From: Laura Gibbons <Laura.Gibbons@arun.gov.uk>
Sent: 15 March 2022 08:42
To: Anita Gardner <Anita.Gardner@arun.gov.uk>
Subject: RE: Planning Consultation on: CM/4/22/DOC - Climping

Application No: CM/4/22/DOC

Site Address: Langford Horsemere Green Lane Climping BN17 5QZ

Description of Works: Approval of details reserved by condition imposed under ref CM/64/19/PL relating to Condition Nos 8 - as-built drawings and 14 - energy efficiency.

As-built Survey

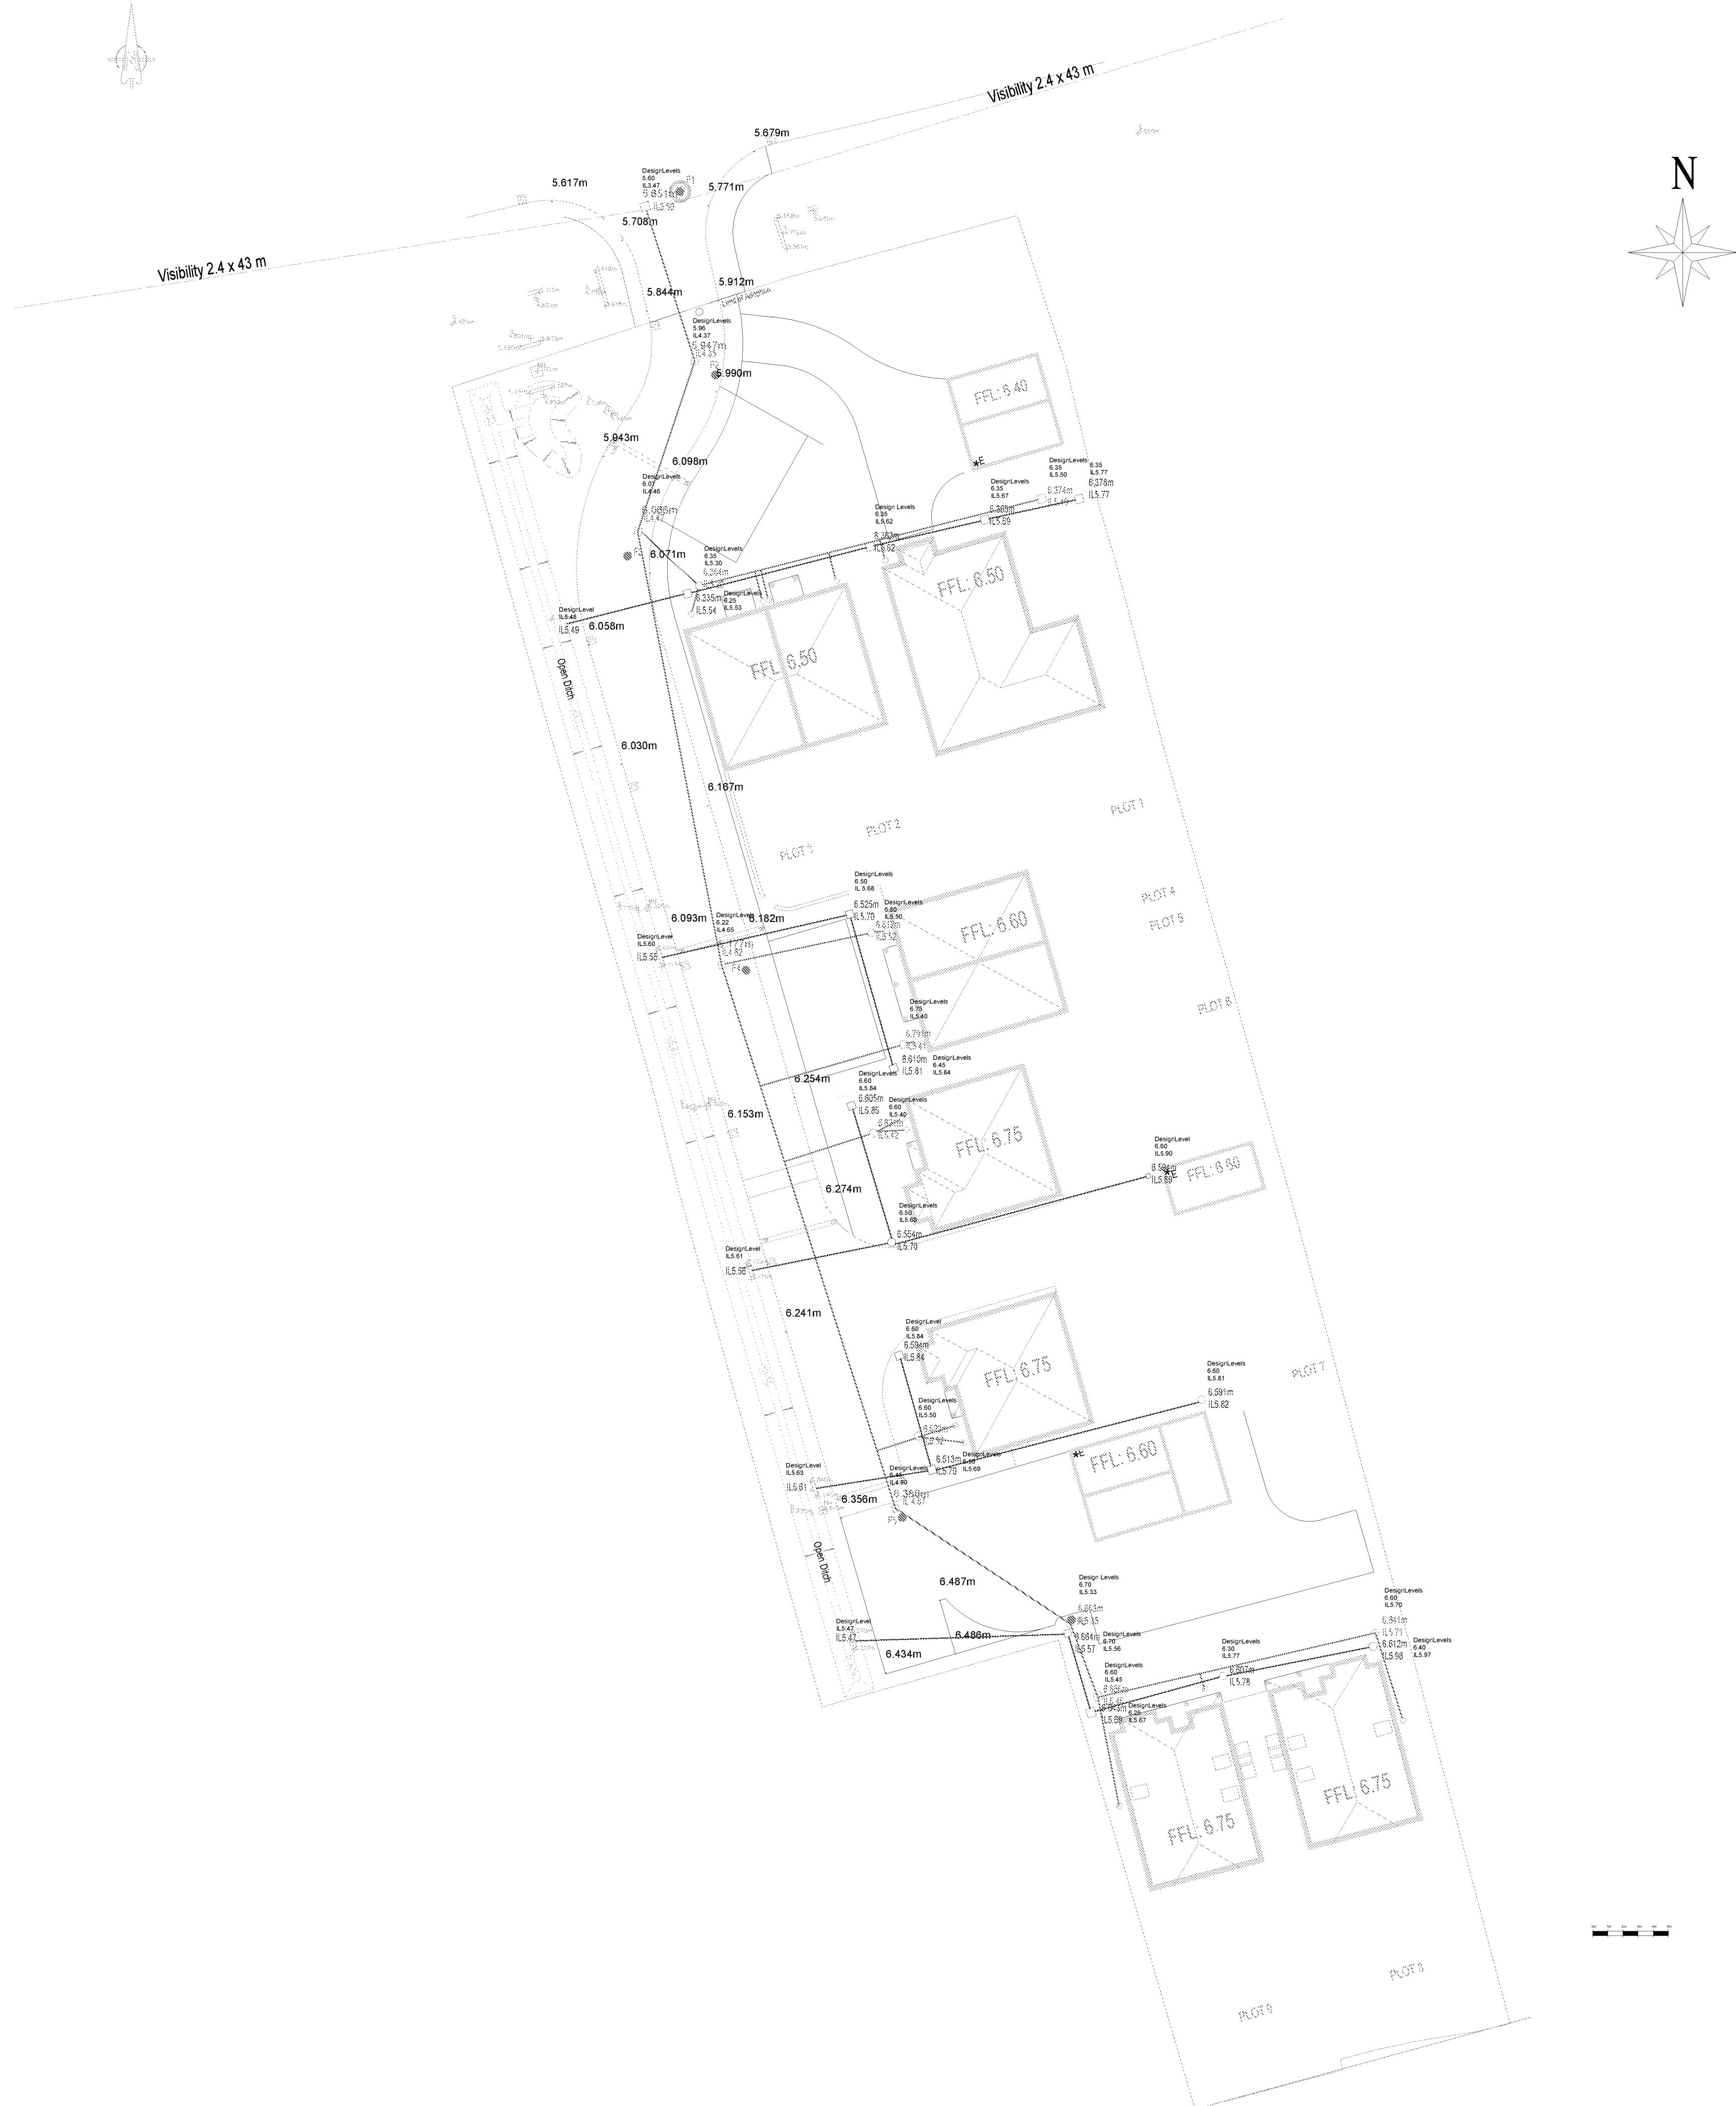
Please provide details of the inspection and verification of control chambers. I.e. surveyed invert and cover levels and good receipts for flow control devices.

- Additional survey data (Asbuilt Drainage Checks Jan22.pdf), which now identifies surveyed cover and invert levels.
- Invoices for SuDS flow control features
